DOUBLE SPUR RANCH MINOR SUBDIVISION

Unresolved from review 1:

DOUBLE SPUR RANCH MINOR SUBDIVISION FINAL PLAT

Sheet: 1 of 2

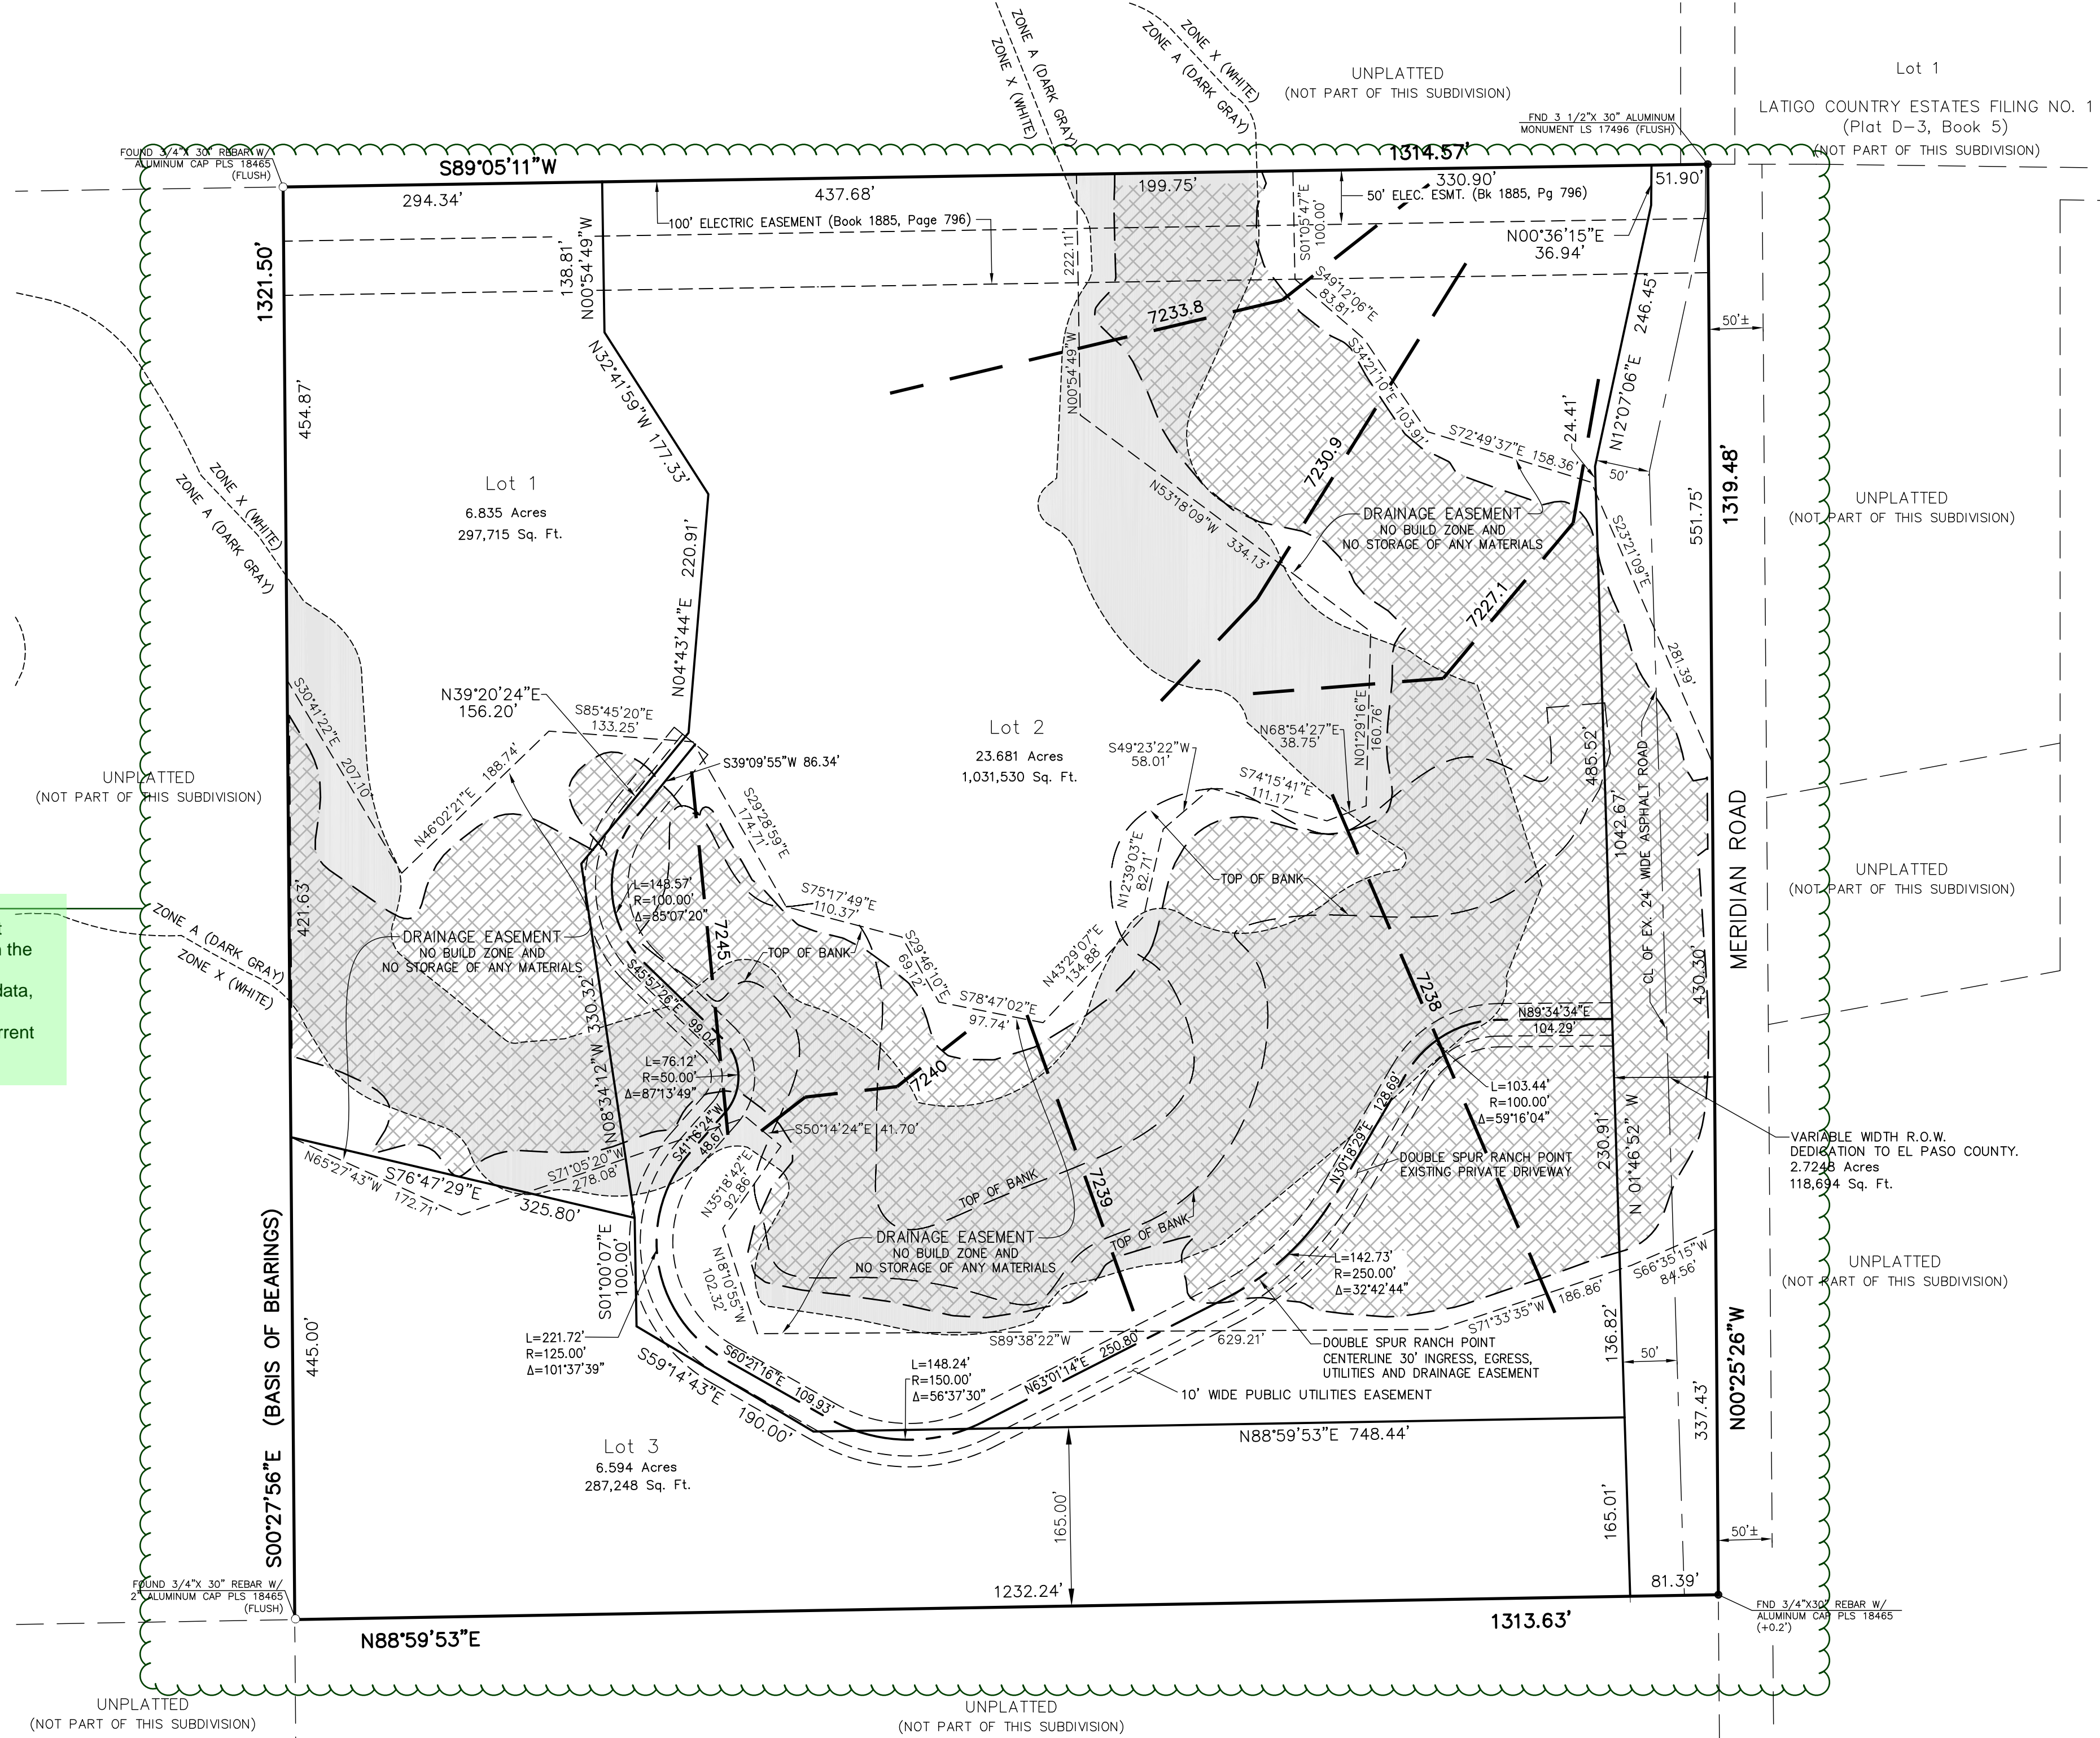
Add the following notes to the plat:

"Lot access shall be restricted to the ingress/egress easement shown on the plat for access to Meridian Road."

"No driveway shall be established unless an access permit has been granted by El Paso County Planning and Community Development Department."

"Individual lot purchasers are responsible for constructing driveways, including necessary drainage culverts from _____ Road per Land Development Code Section 6.3.3.C.2 and 6.3.3.C.3. Due to their length, some of the driveways will need to be specifically approved by the (name of Fire District)."

"The private roads and driveways as shown on this plat will not be maintained by El Paso County until and unless the streets are constructed in conformance with El Paso County standards in effect at the date of the request for dedication and maintenance."

"The subdivider agrees for itself and its successors and assigns that subdivider and/or said successor and assigns shall be required to maintain drainage channel that flows through the site. The County is not responsible for maintenance of the drainage easement."

"The subdivision has been found to be impacted by geologic constraints. Mitigation measures and explanation of constraints in the area can be found in the report Soil, Geology, and Geologic Hazard Study by Entech Engineering, Inc. November 30, 2022 in file PCD File No. MS-235, available at the El Paso County Planning and Community Development Department."

Please use specific verbiage:
Note Regarding Reports on File:
The following reports have been submitted in association with the Preliminary Plan or Final Plat for this subdivision and are on file at the County Planning and Community Development Department: Transportation Impact Study; Drainage Report; Water Resources Report; Wastewater Disposal Report; Geology and Soils Report; Fire Protection Report; Wildlife Hazard Report;

unresolved v1: Please add the following note
Soil and Geology Conditions:
Geologic Hazard Note-Final Plat: (to be customized based upon the individual circumstances)
The following lots have been found to be impacted by geologic hazards. Mitigation measures and a map of the hazard area can be found in the report (Title of Report, generally from the Preliminary Plan file) by the (author of the report) (date of report) in file (name of file and file number) available at the El Paso County Planning and Community Development Department:
•Downslope Creep: (name lots or location of area)
•Rockfall Source:(name lots or location of area)
•Rockfall Runout Zone:(name lots or location of area)
•Potentially Seasonally High Groundwater:(name lots or location of area)
•Other Hazard:
In Areas of High Groundwater:
Due to high groundwater in the area, all foundations shall incorporate an underground drainage system.

Please add this note:
Gas and Electric:
The subdivider/developer is responsible for extending utilities to each lot, tract or building site.

Remove irrelevant notes.

Please update to this and leave a line for "Planning and Community Development Director" and a line for the date

Unresolved v1: Remove.

DOUBLE SPUR RANCH MINOR SUBDIVISION FINAL PLAT

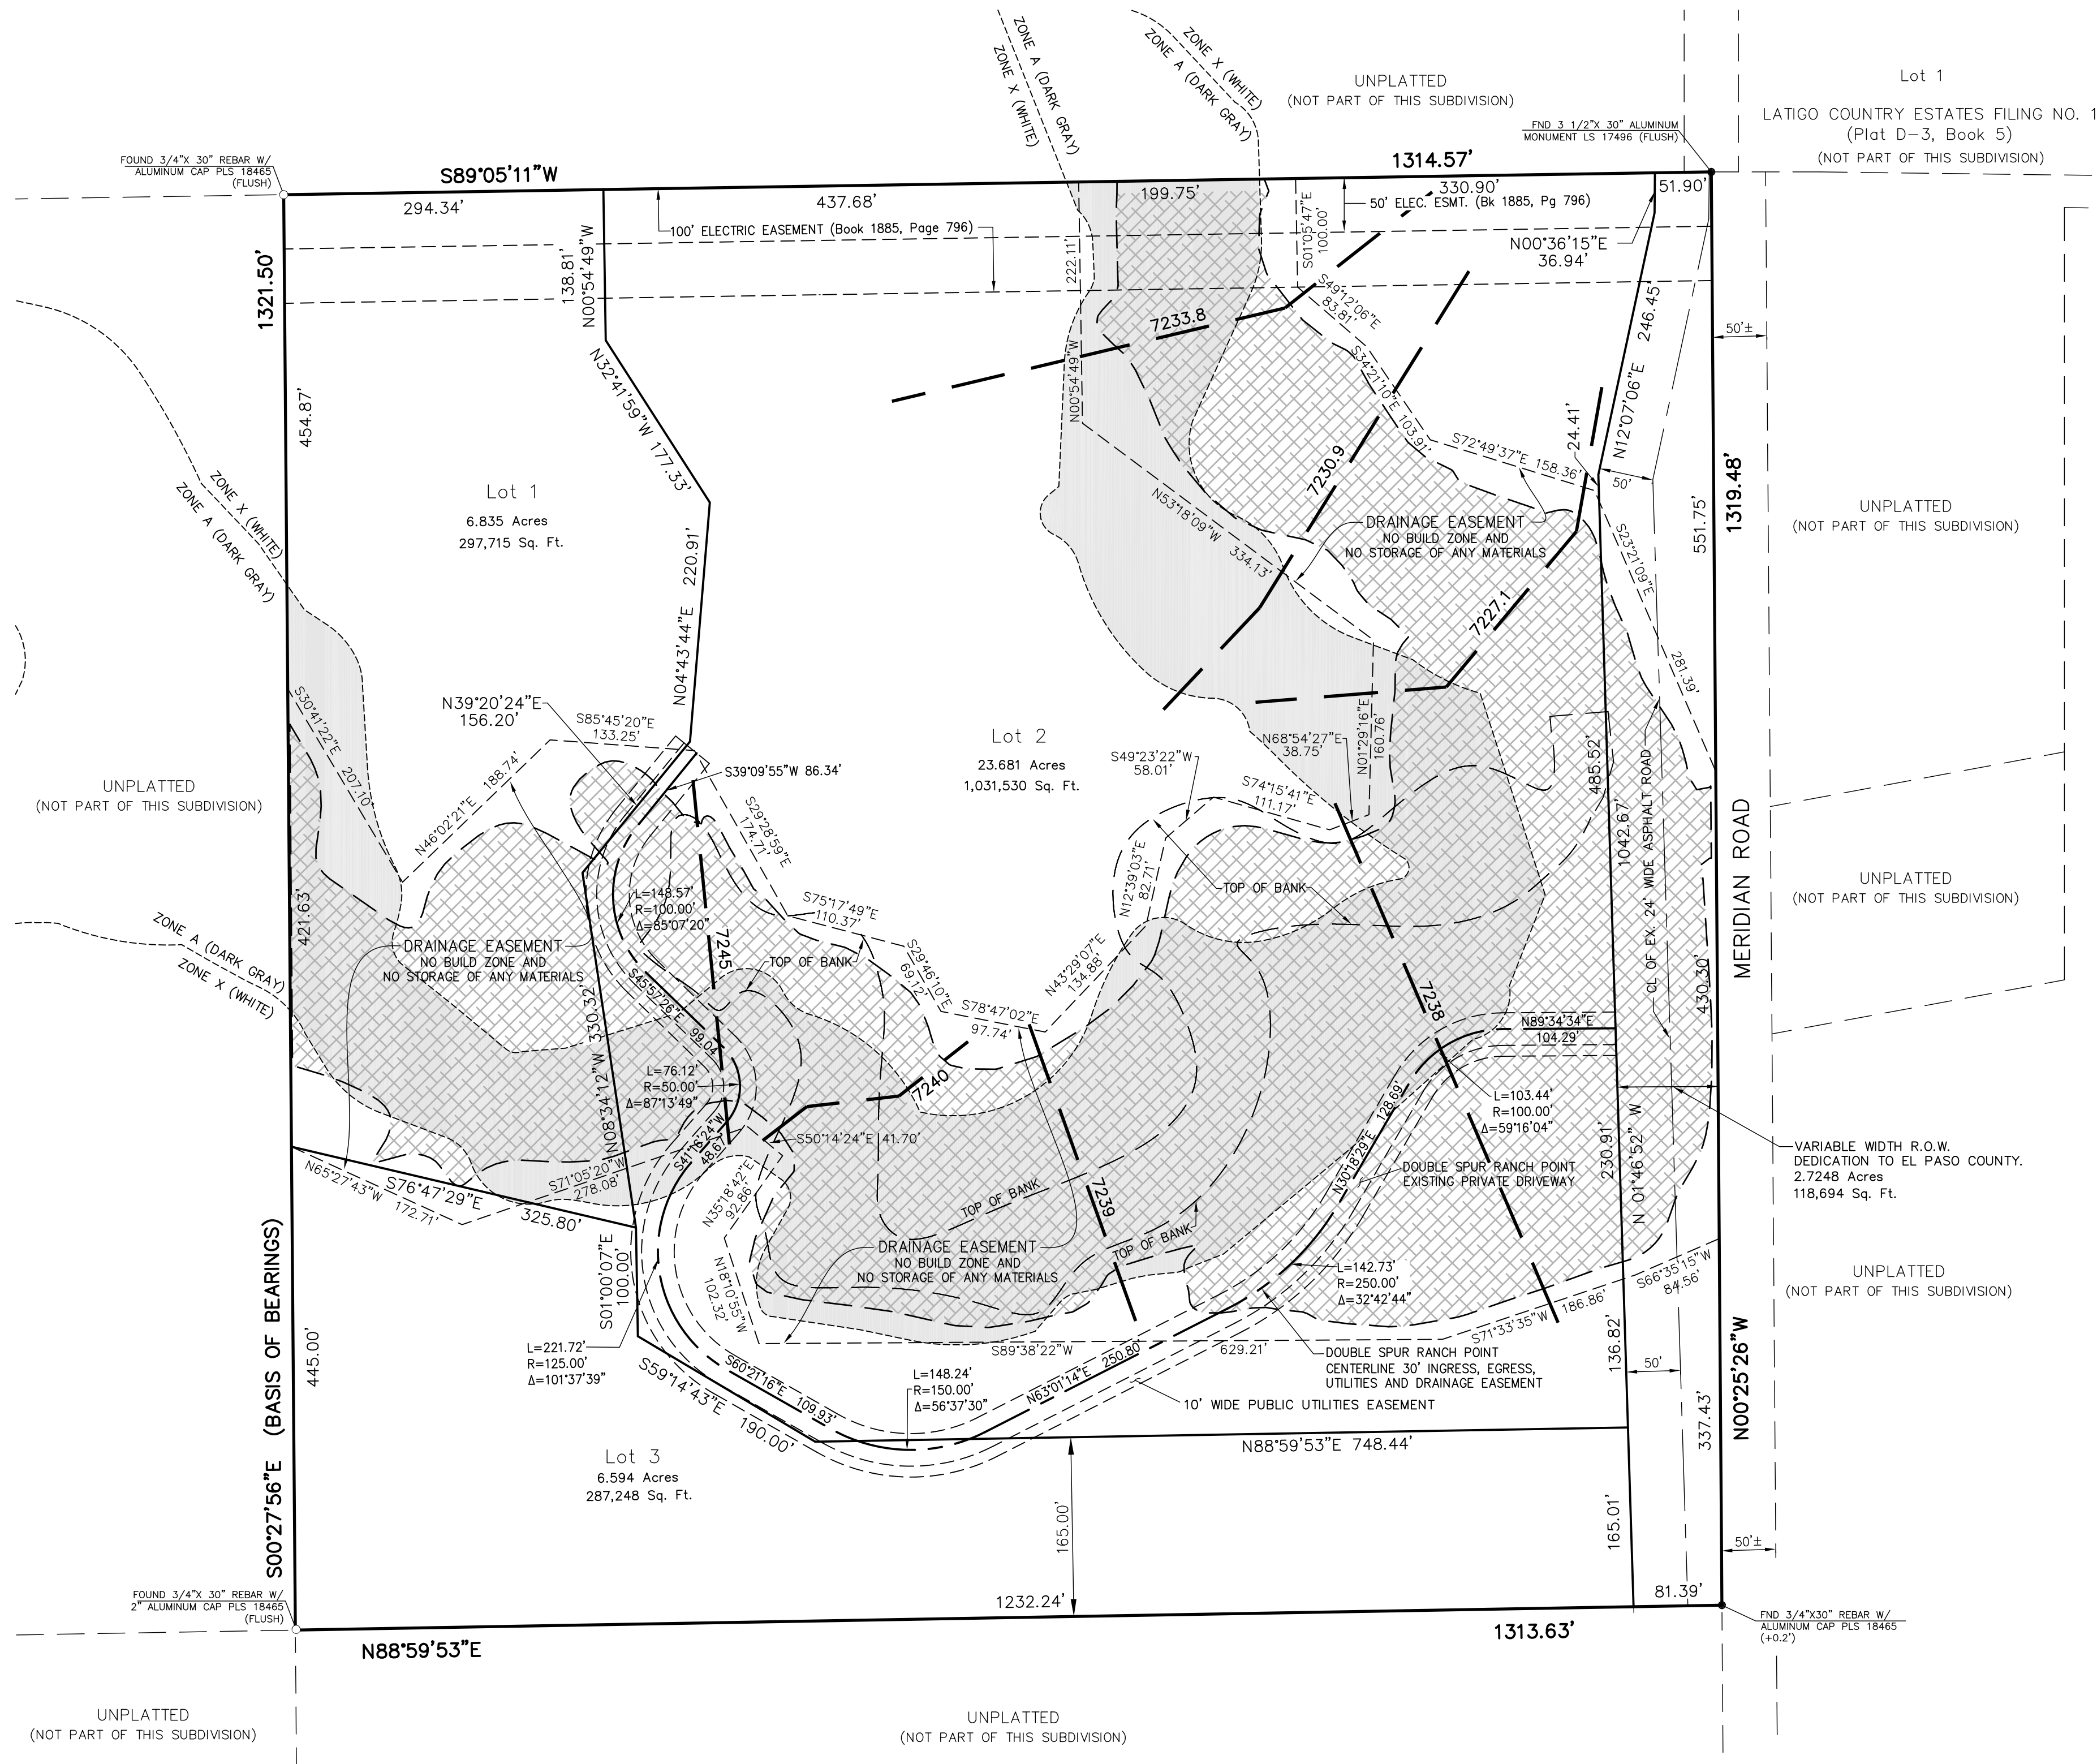
Remove all existing and proposed structures, concrete pads, and fencing.

Unresolved from review 1: Remove the exiting building outline, fence, and roadway linework from the plat.

UNRESOLVED V1: Structures do not need to be depicted on the plat, add to the site plan drawing

UNRESOLVED V1: Any parcel not associated with the subdivision will need to read as: "Not a part of this subdivision"

Unresolved from review 1: The drainage easement provided shall encompass both the drainage channel and FEMA Floodplain.

Unresolved from review 1: Show and label drainage easement on plat per requirements. Also label it as a "no build zone" and "no storage of any materials".

For all three lots, include the addresses included by pikes peak regional building department

Unresolved from review 1: Remove fence, existing road and existing concrete pad from the plat.

Please add dimensions/width of ROW and public or private rd

please label this as a private driveway

Please provide a legend for line work

This does not need to be included with the plat, please remove

Unresolved from review 1: Contact/coordinate with the Fire Department regarding Land Development Code Section 6.3.3.C.3.
Modification to the easement and/or existing driveway may be necessary to comply with the referenced LDC criteria.

Unresolved from review 1: Create a joint maintenance agreement for the shared easement/driveway.
Add a plat note referencing the recorded maintenance agreement and the reception number.

Maintenance agreement should provide details about the division of financial responsibility and division of decision-making (e.g. who decides if repair/maintenance is needed and what if there's a disagreement)

Unresolved from review 1: Show ROW preservation for Meridian Road in the amount of 50 feet from the centerline of the road.

Unresolved v1: Please remove
